**From:** Carruthers, David  
**Sent:** 11 January 2022 11:16  
**To:** Milnes, Louise  
**Cc:** [planning.comments@york.gov.uk](mailto:planning.comments@york.gov.uk)  
**Subject:** 21/02701/LBC

David Carruthers | Conservation Architect  
t: 01904 552556 | e: [david.carruthers@york.gov.uk](mailto:david.carruthers@york.gov.uk)

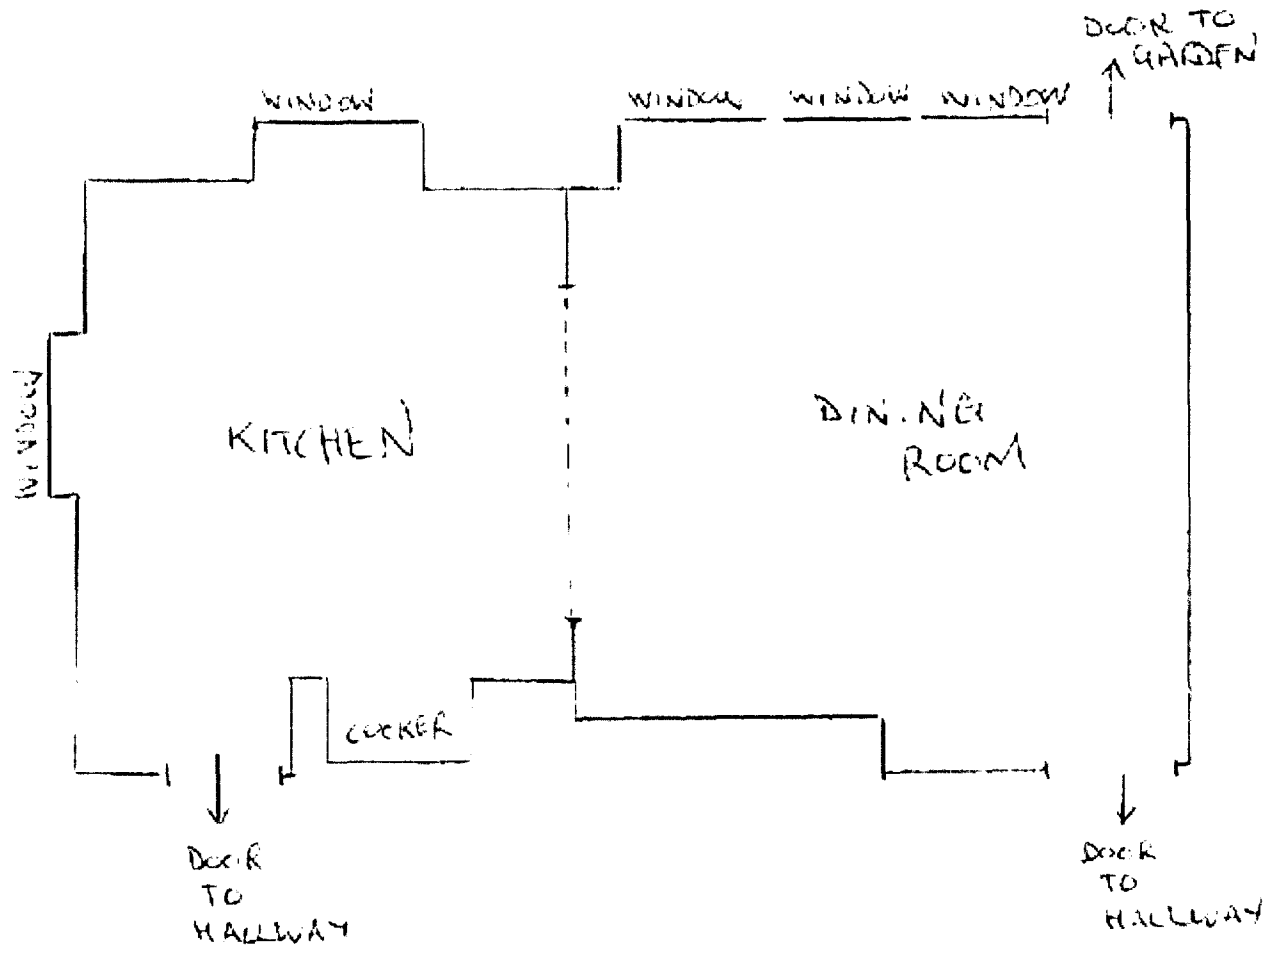
As you know I met the applicant on site and we agreed a way forward in terms of regularising the original approval. I'm happy to support the application as it concurs with my discussions on site. The removal of the rooflight and the reduction in the kitchen wall opening will reverse the harm to heritage significance caused by the works carried out.

The applicant needs to confirm the specific opening size for the kitchen wall.
